CITY OF ALBUQUERQUE
PUBLIC WORKS DEPARTMENT
UTILITY DEVELOPMENT DIVISION/HYDROLOGY SECTION

PRE-DESIGN CONFERENCE

DRAINAGE FILE/ZONE ATLAS PAGE NO.: J/4 DATE: 5/21/92
EPC NO.: _____ DRB NO.: _____ ZONE: _____
SUBJECT: KASBORK MFG
STREET ADDRESS: _____
LEGAL DESCRIPTION: 1416 FIRST ST.

RE: DRAINAGE PLAN FOR AN ADDITION TO KASDORF MANUFACTURING, PHASE I
(J-14/D99) ENGINEER'S STAMP DATED JUNE 8, 1992

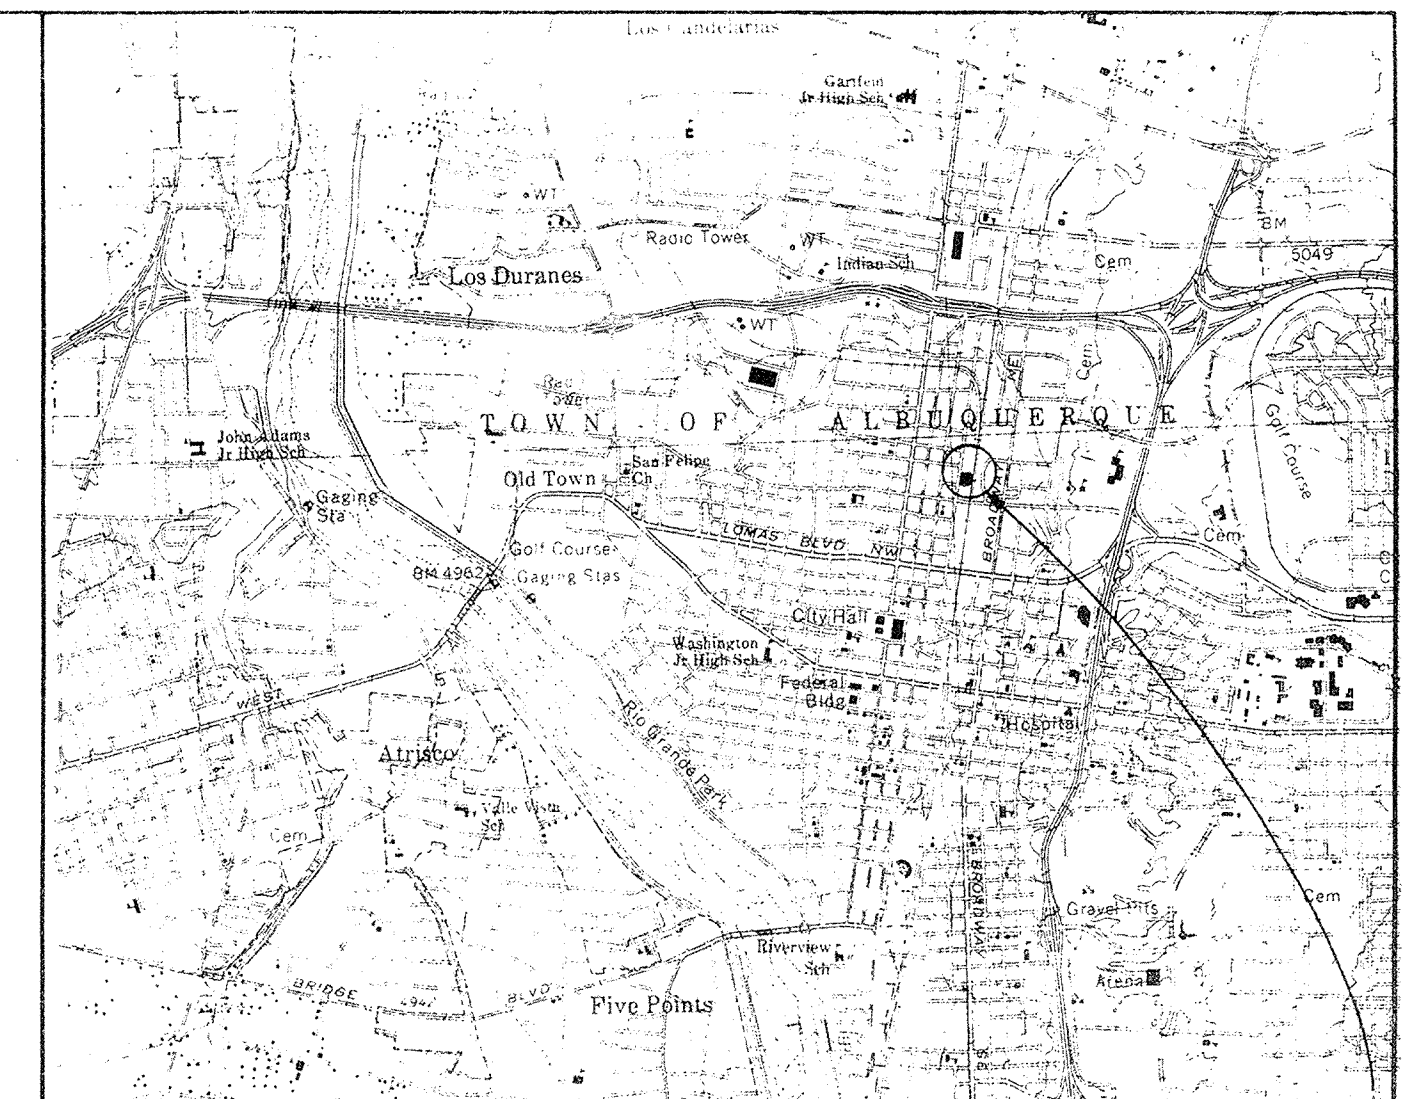
- An APPROVED DRAINAGE plan is required for building permit approval
- Given that the ROOF AREA is replacing a parking lot, FREE discharge is appropriate. However, the DRAINAGE BASIN must ~~be~~ remain the same.
- The existing FLOW condition is to FIRST STREET.

Please be advised that when Phase II submittal is submitted for review, all the developed runoff must be routed to First Street, NW. Catch basin within the parking lot with a tie to the existing inlet on First Street will be appropriate.

Based on the information provided on your submittal of June 8, 1992, the above referenced plan is approved for Building Permit.
